**NOTICE OF VIOLATION AND ORDER TO CORRECT**

Responsible Party 1: IN FIRM GROUP THE PO BOX 10189 PORTLAND, ME 04104		
Location 150 MIDDLE ST	CBL 029 A00101D	Inspection Date 8/18/2017
Inspector Alan Greene	Inspection Type FP Routine Inspection	Status Failed

SHEET TITLE:  
 LIFE SAFETY PLAN

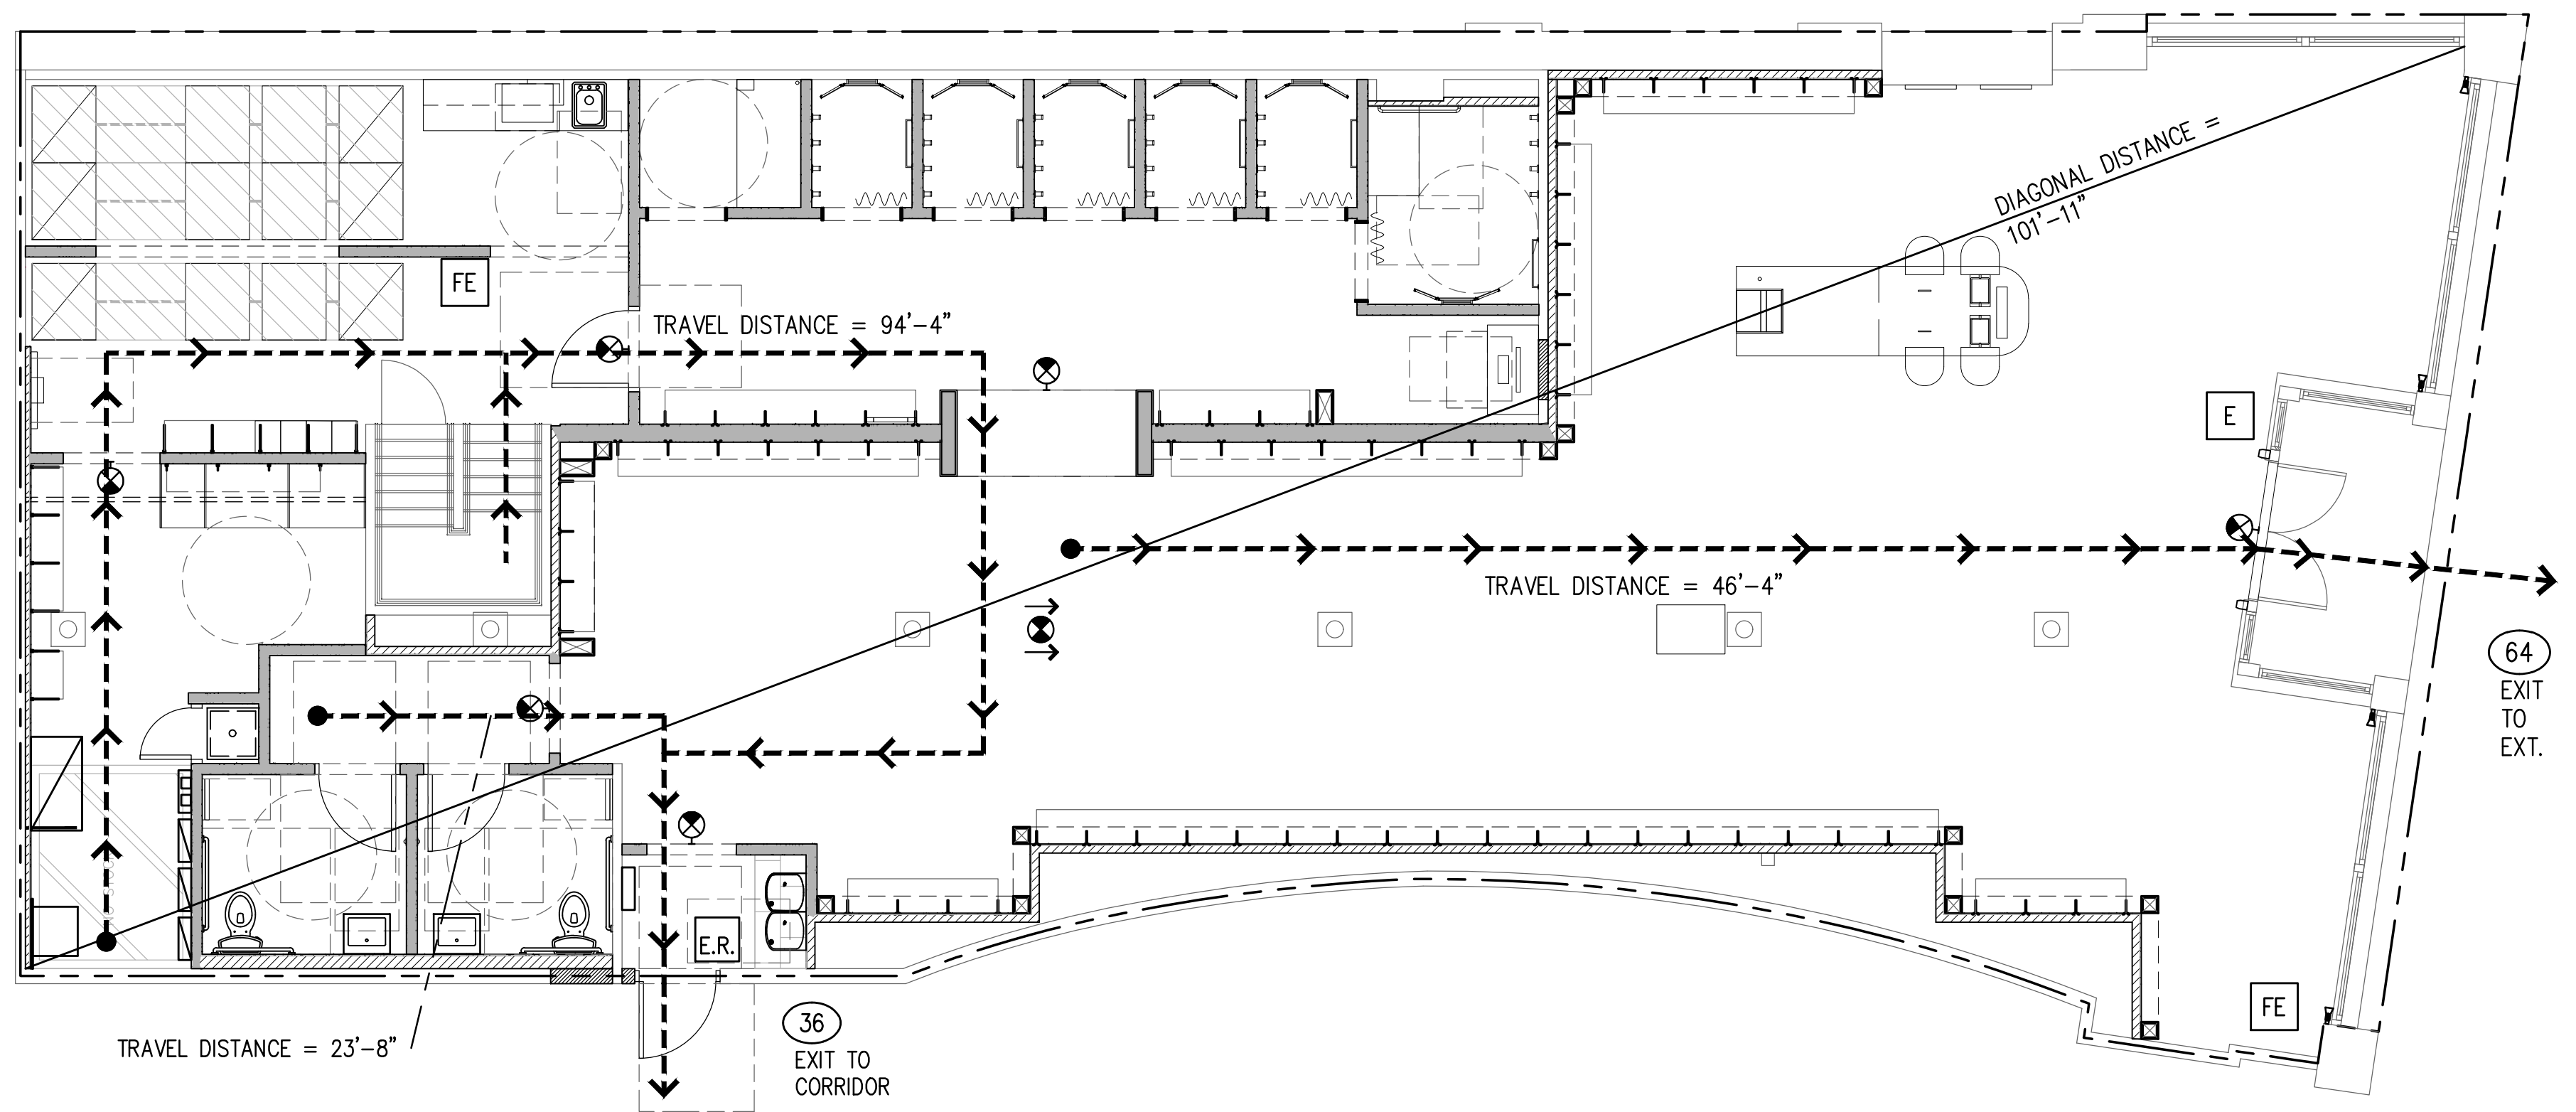
Violation	Proposed Date of Completion
NFPA 101-7.10.9 TESTING AND MAINTENANCE EXIT SIGNS REQUIRE MAINTENANCE; 7.10.9.1 Inspections. Exit signs shall be visually inspected for operation of the illumination sources at intervals not to exceed 30 days. 7.10.9.2 Testing. Exit signs connected to, or powered with, a battery-operated emergency illumination source shall be tested and maintained in accordance with 7.9.3. 7.9.3 Periodic Testing of Emergency Equipment 7.9.3.1 Required emergency lighting systems shall be tested in accordance with one of the three options offered by 7.9.3.1.1, 7.9.3.1.2, or 7.9.3.1.3. 7.9.3.1.1 Testing of required emergency lighting systems shall be permitted to be conducted as follows: (1) Functional testing shall be conducted monthly with a minimum of 3 weeks and a maximum of 5 weeks between tests, for not less than 30 seconds, except as otherwise permitted by 7.9.3.1.1(2). (2) The test interval shall be permitted to be extended beyond 30 days with the approval of the authority having jurisdiction. (3) Functional testing shall be conducted annually for a minimum 1-1/2 hours if the emergency lighting system is battery powered. (4) The emergency lighting equipment shall be fully operational for the duration of the test required by 7.9.3.1.1(1) and (3). (5) Written records of visual inspections and tests shall be kept by the owner for inspection by the authority having jurisdiction. Parking garage area. Exit sign over a locked door. Sign should be removed and put over the exit door beside the overhead door. Both doors that go into elevator room are labeled exit, but are locked.
